From: [Airspace Protection](#)
To: [Jessica Fountain](#)
Cc: [David Glasgow](#); [Airspace Protection](#); [Airspace Protection](#)
Subject: RE: Notice of Exhibition – Towers 2A and 2B Australia Ave Sydney Olympic Park (SSD-9383)
[SEC=OFFICIAL]
Date: Wednesday, 27 November 2019 6:43:42 PM

Our File F18/2634-31

The Department of Planning, Industry and Environment has received an Environmental Impact Statement (EIS) for the Towers 2A and 2B Australia Ave Sydney Olympic Park (SSD-9383).

DRAWING NO.
DA-033

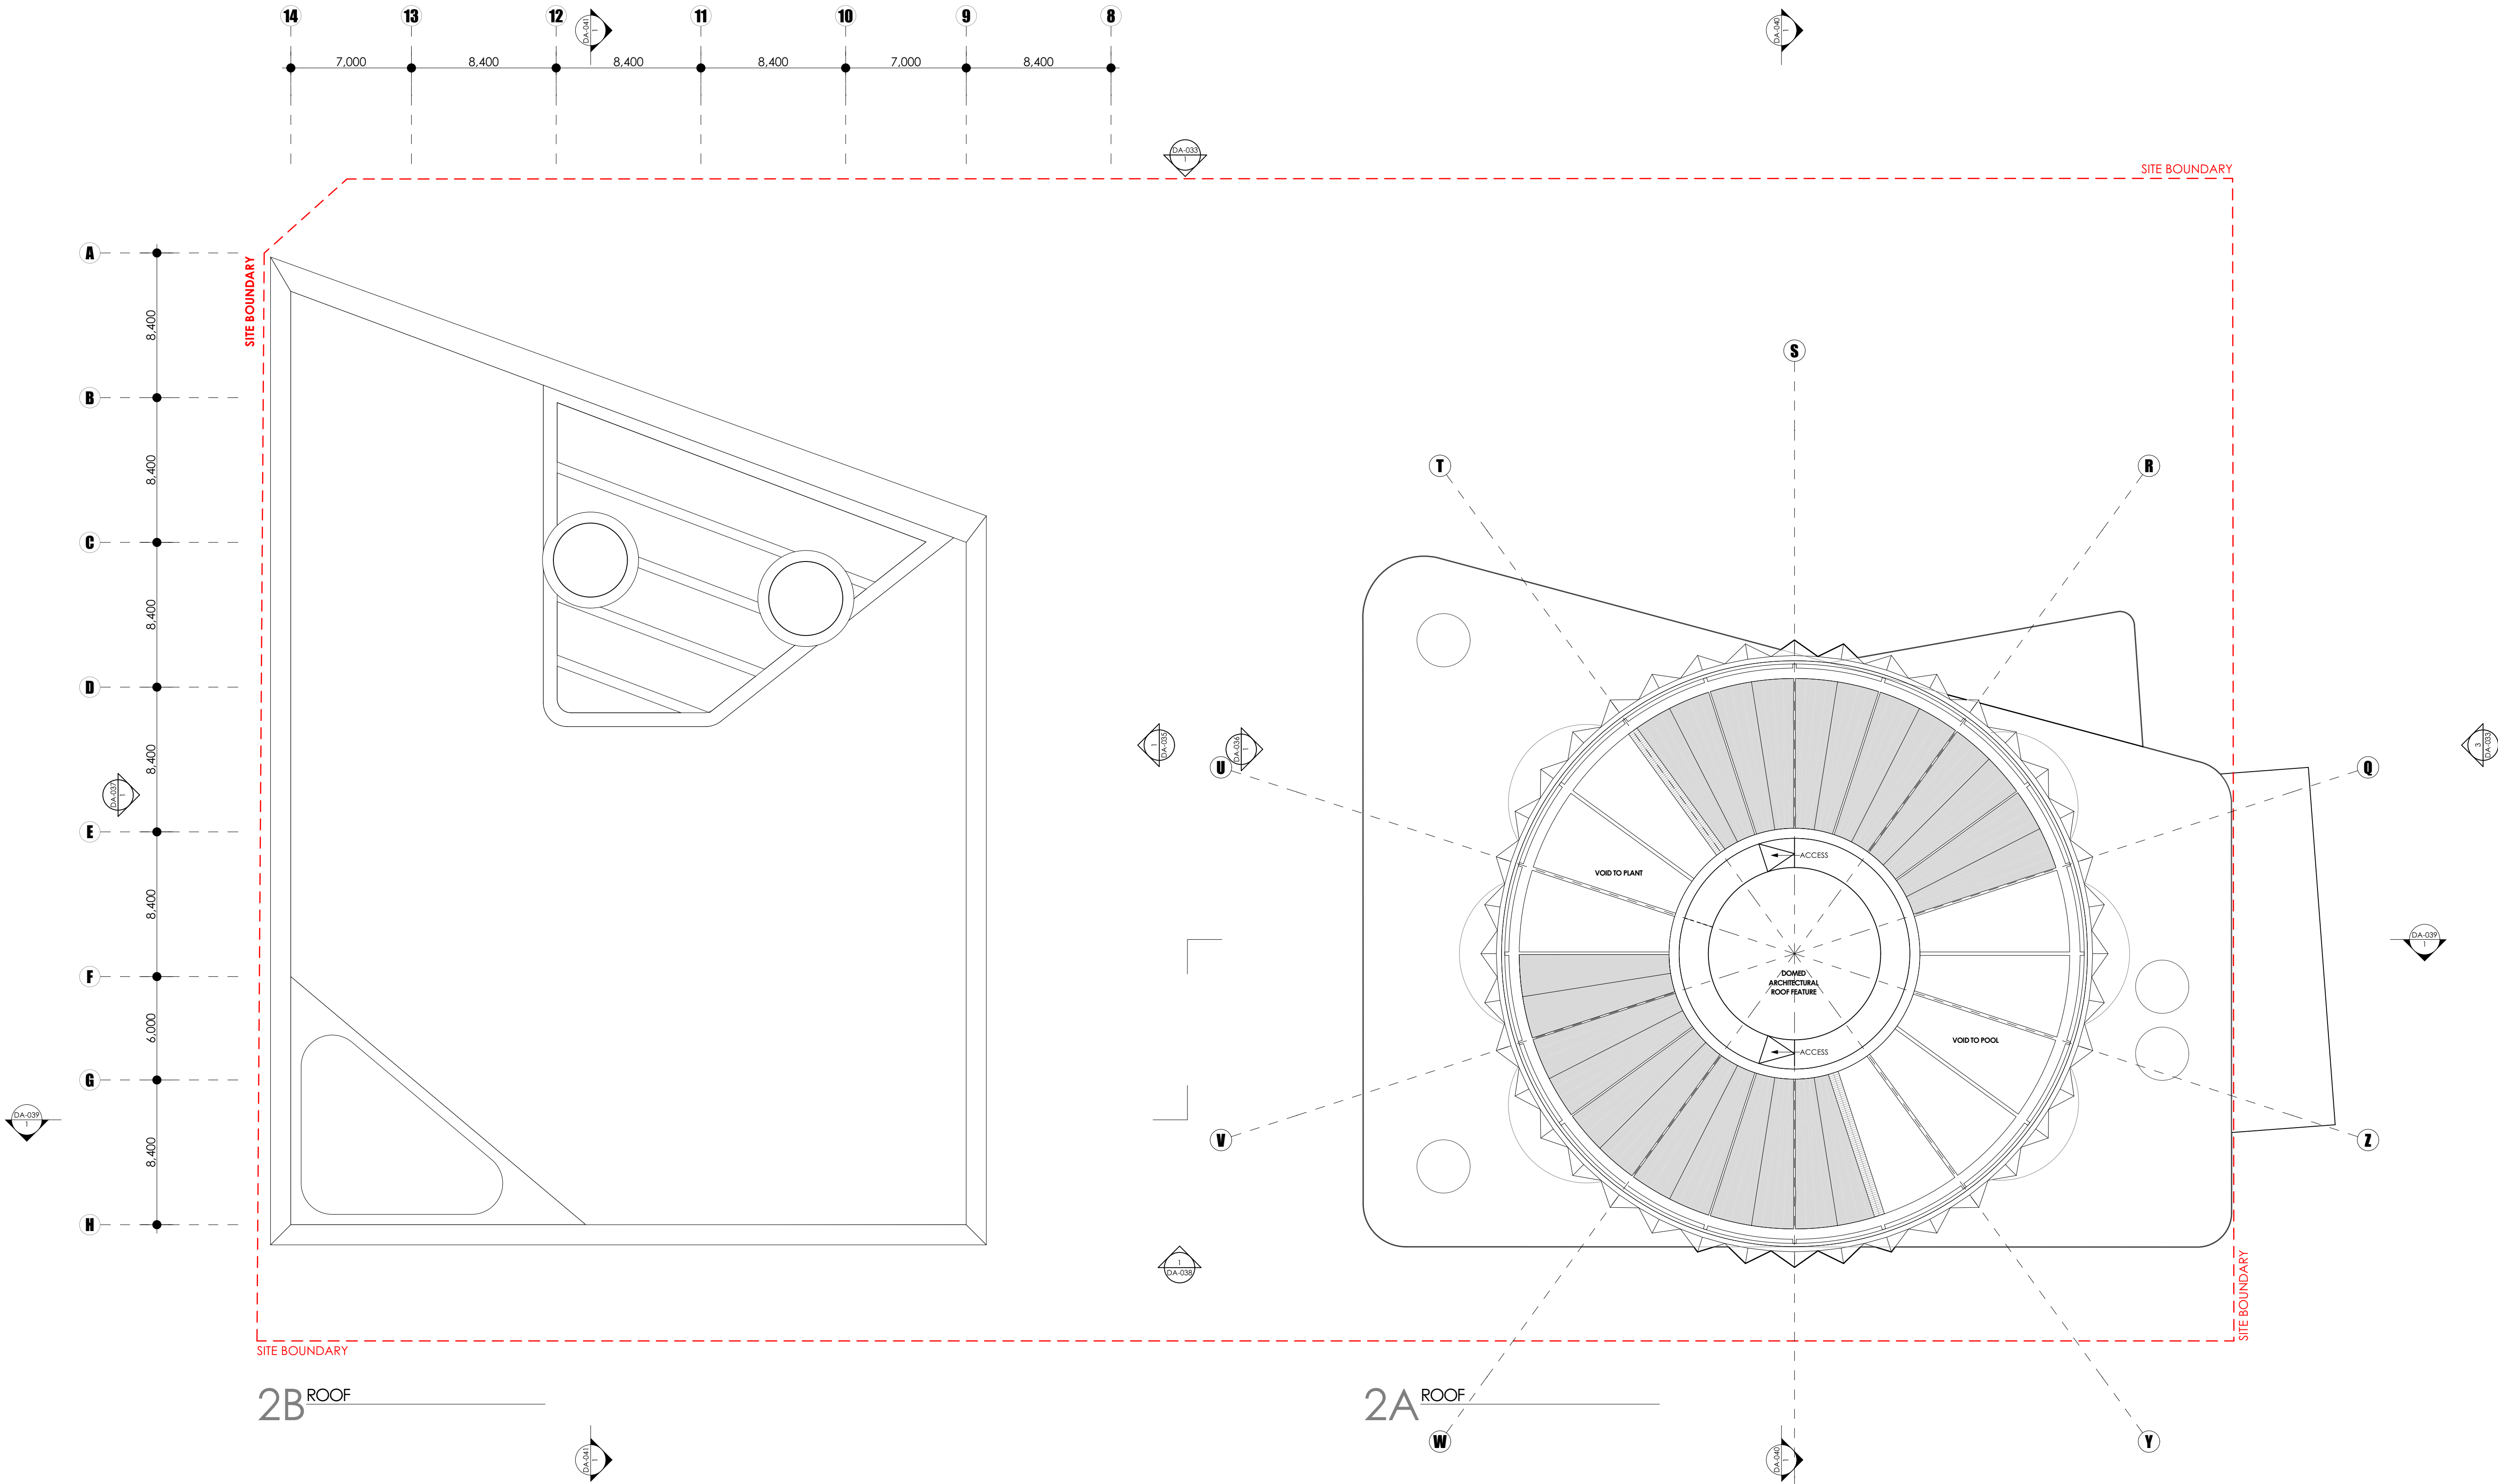
It appears that the taller building 2A will be RL 135.9m.

From the information provided and previous assessments in the area, the building will be in the vicinity of the edge of the Outer Horizontal Surface for Sydney Airport. In any case, the height of the Outer Horizontal Surface is RL 156m. Therefore, the building should not infringe prescribed airspace and will not be an 'obstacle' in aviation terms. Sydney Airport

Therefore CASA does not need to assess the building under the Airspace Regulations. CASA has no objection to the development.

In future, it is possible that the tower cranes used to construct the building could infringe prescribed airspace and therefore require Approval under the Airspace Regulations. Again, Sydney Airport would be able to confirm whether the cranes will infringe prescribed airspace (and describe the Approval process).
